DRB Project Number: PR-2018-1580 (1005234)
Application Number: SI-2018-00153
Project Name: Hotel Wyndam – Apartment Conversion

EXHIBIT 'A' – Response to comments

B1 ADA PARKING DETAILS
1/4" = 1'-0"

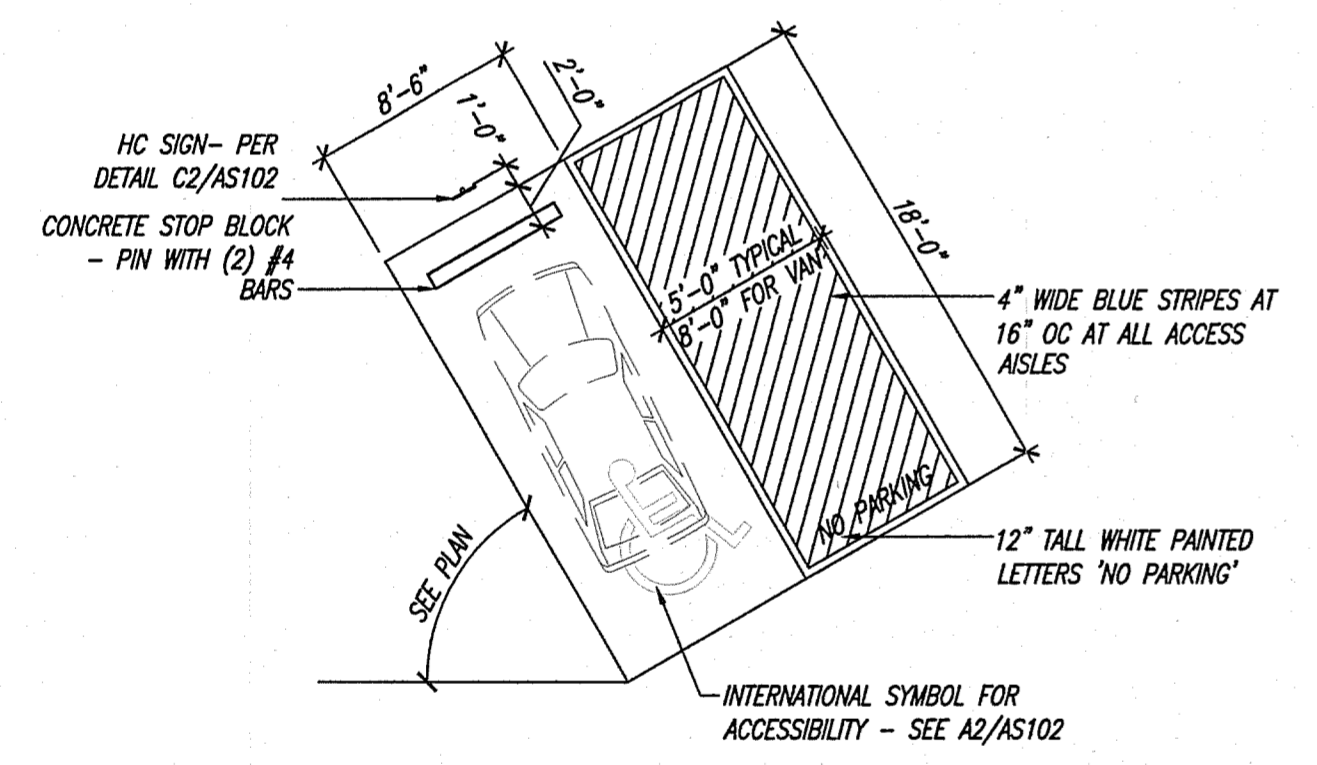
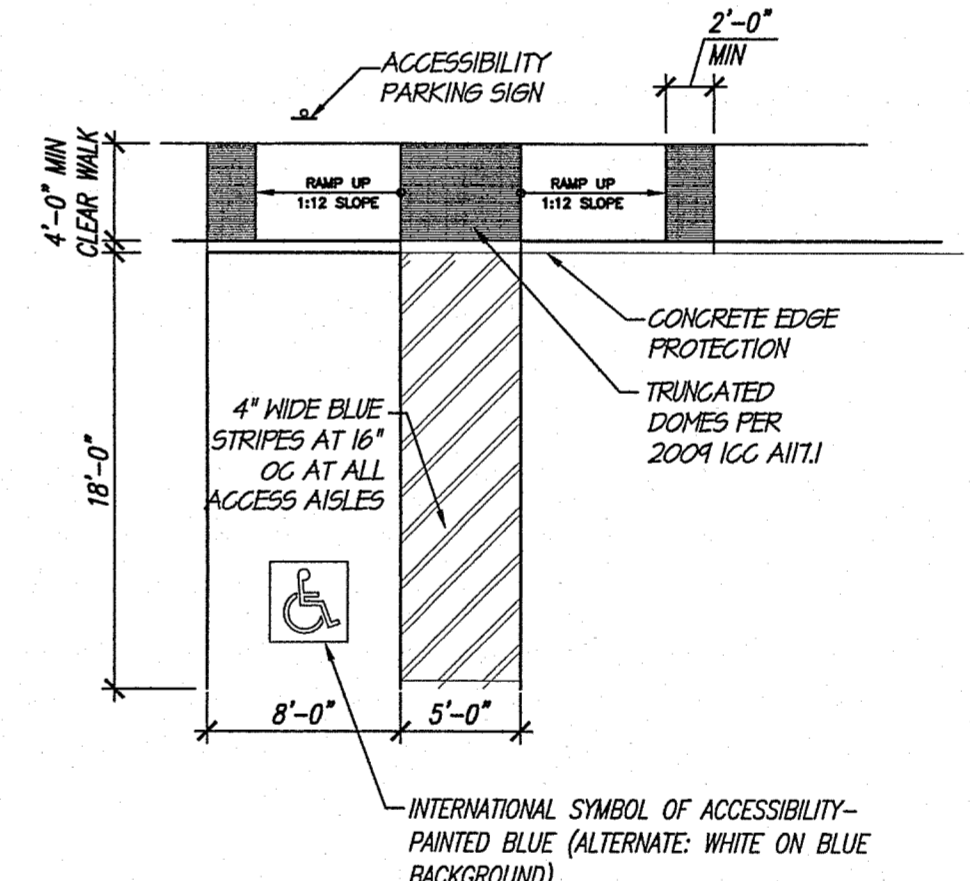
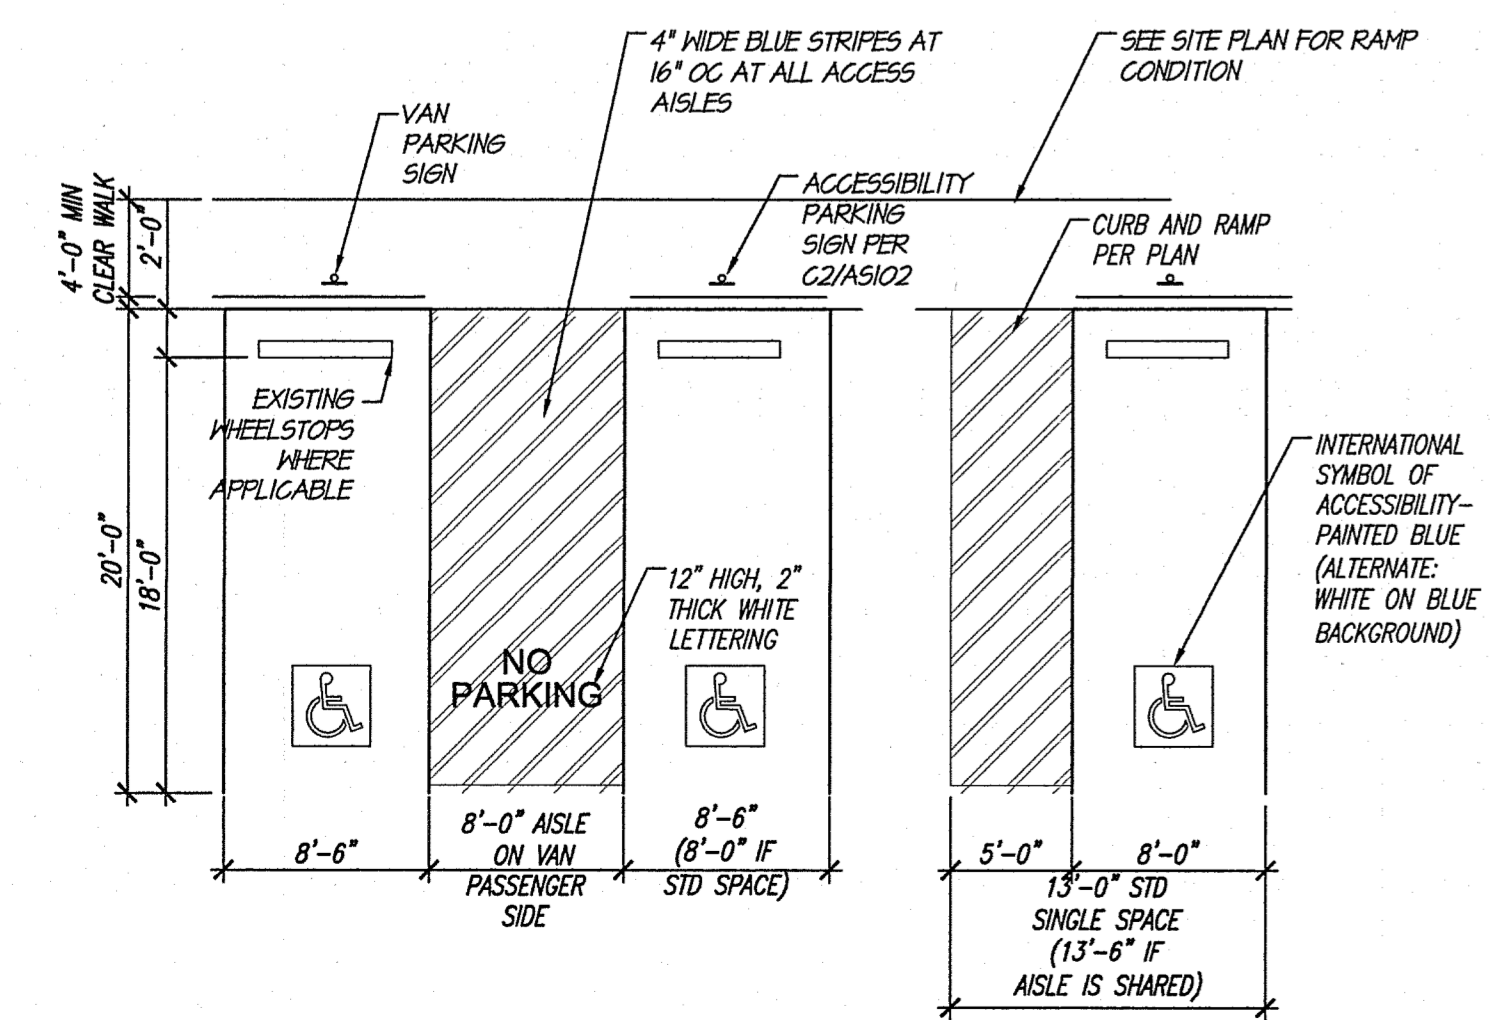
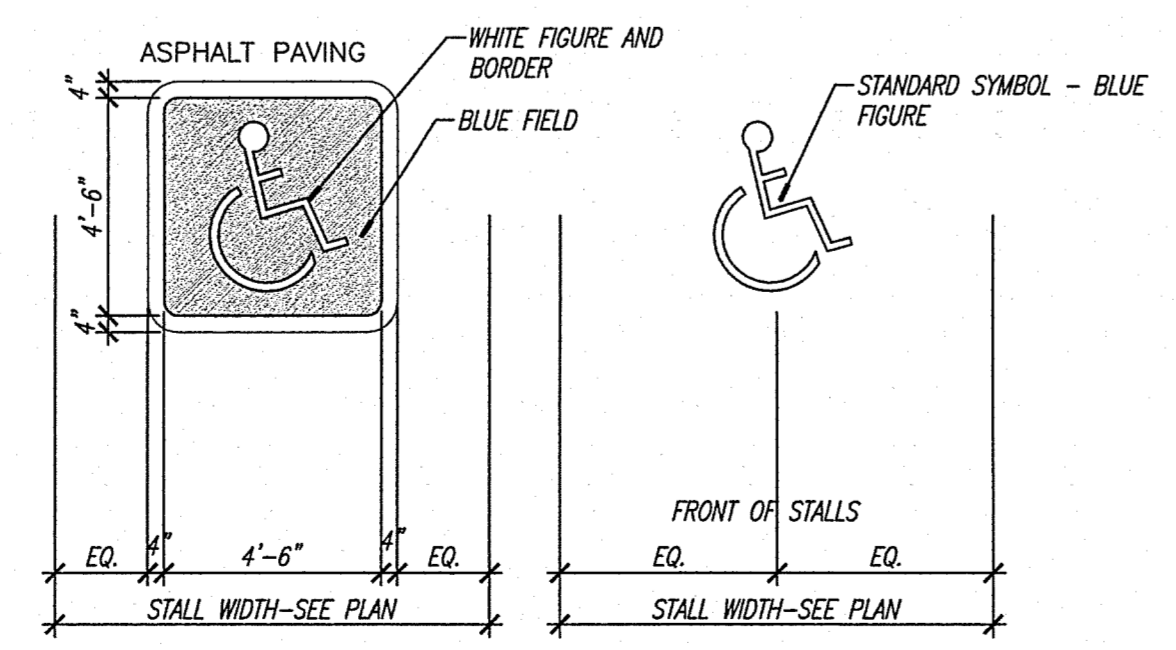
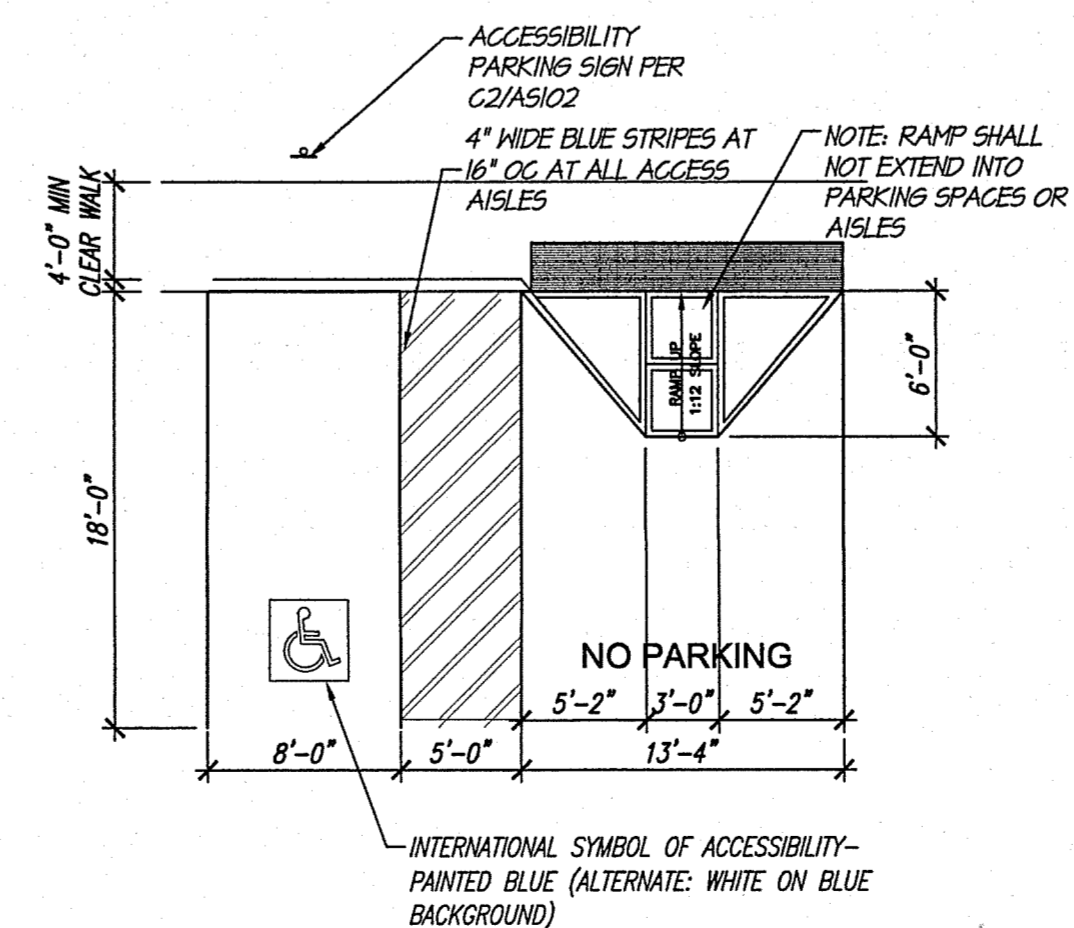
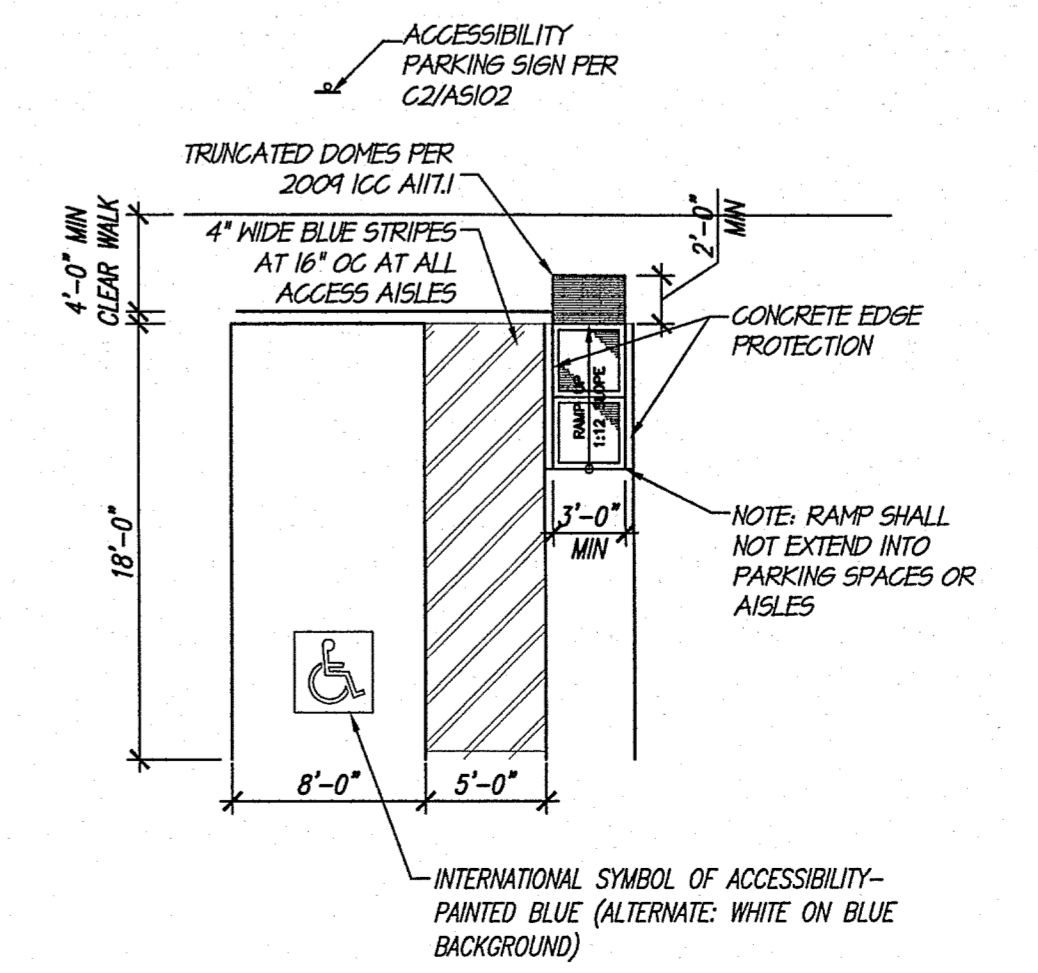
- a. **ADA accessible spaces have been revised to include access aisles of 5' minimum and Van accessible aisles as 8' in width.**
8. *The ADA accessible parking sign must have the required language per 66-7-352.4C NMSA 1978 "Violators Are Subject to a Fine and/or Towing." Please call out detail and location of ADA signs.*

- a. **"NO PARKING" annotation added to the Site Plan.**
10. *ADA curb ramps must be updated to current standards and have truncated domes installed.*
 - a. **Non-compliant ramps have been revised in the drawings per current standards. Details articulating truncated domes are indicated on AS102.**

11. *Motorcycle parking spaces shall be designated by its own conspicuously posted upright sign, either free-standing or wall mounted per the zoning code.*

- a. **On-street parking dimensions are indicated on detail located on AS102.**
- 19. *Please show the details of the angled parking including the angle.*

- a. **Signage is noted on plan. Sign detail is located on AS102.**
- 12. *Show all drive aisle widths and radii. Some dimensions are not shown.*
 - a. **Width and radii of drive aisles have been added to the drawings.**

- a. **Multiple angled parking configurations occur on site. Dimensions in the details on AS102 are called out on the Site Plan.**
